## Department of Transportation

RE: Multi-Family Development - Fishers Canyon (P274)

The Traffic Impact Study dated July 3, 2023 by Kimley-Horn has been reviewed by a CDOT Traffic Engineer. Their comments are as follows:

FIGURE 6
VENETUCCI THOMPSON THRIFT
EL PASO COUNTY, COLORADO
PROJECT TRIP DISTRIBUTION

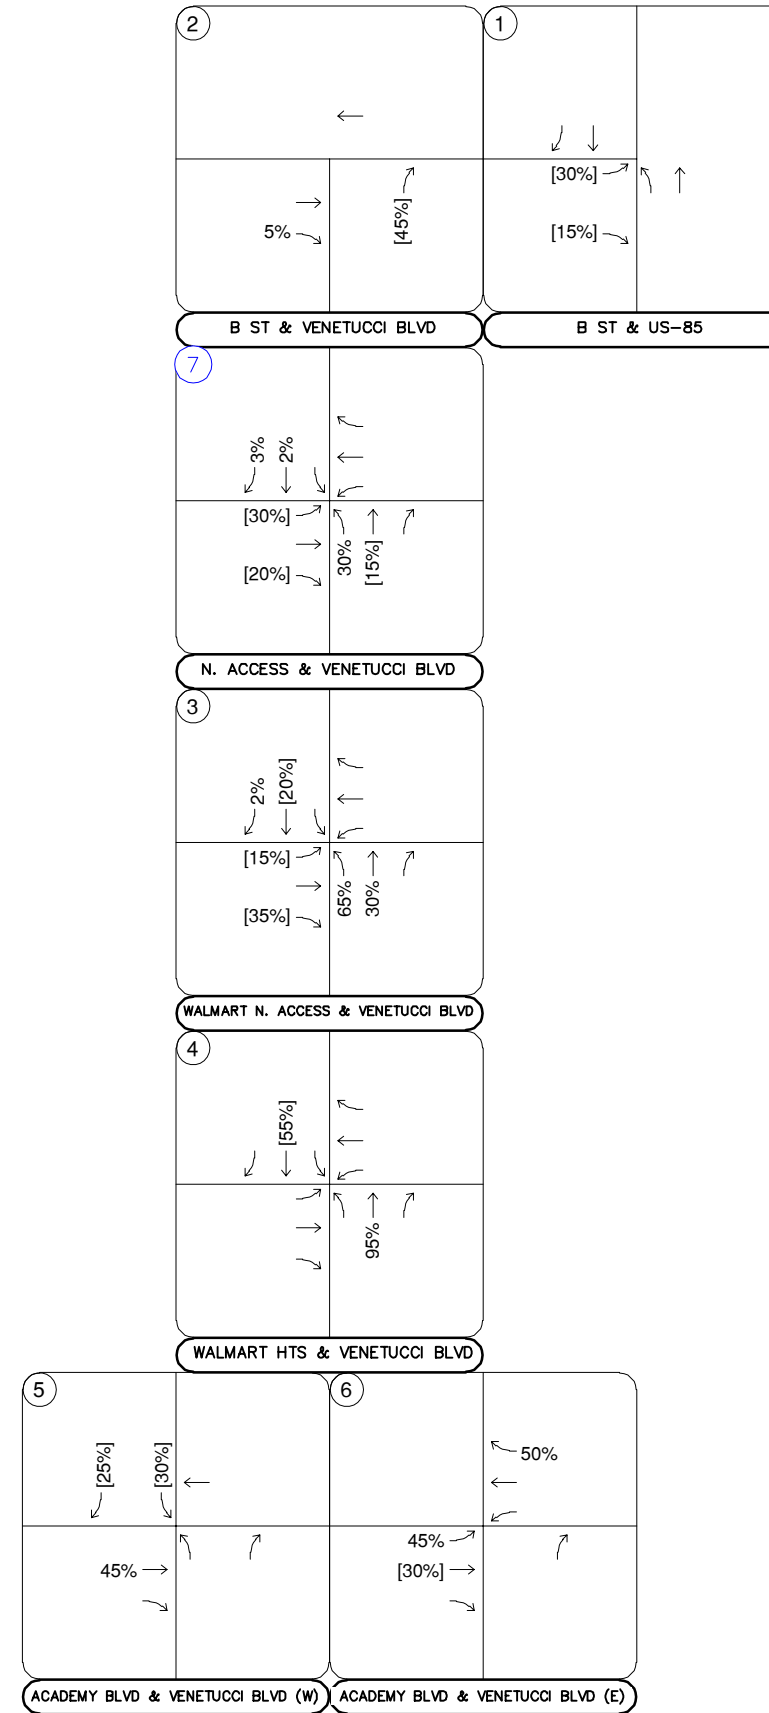
- **Distribution (Figure 6):** Traffic using B St is underestimated considering the existing AADT. Assume 10% entering/exiting trips West of intersection #2 and 15% North, and 15% East of intersection #1. The remaining 60% of entering/exiting trips would be from/to South through Academy Blvd. Use this distribution for both AM and PM peaks.
- **Traffic Signal Timings:** Use the attached timings for the existing conditions. Optimization is allowed for future scenarios, but clearance intervals should remain the same as in the existing conditions. Attached are the signal timings for US-85 & B St.
- Update the analysis and resubmit the study.
- In regard to the T-intersections exhibit as submitted CDOT will withhold comments at this time due to changes requested in the comments above that may change the configuration.
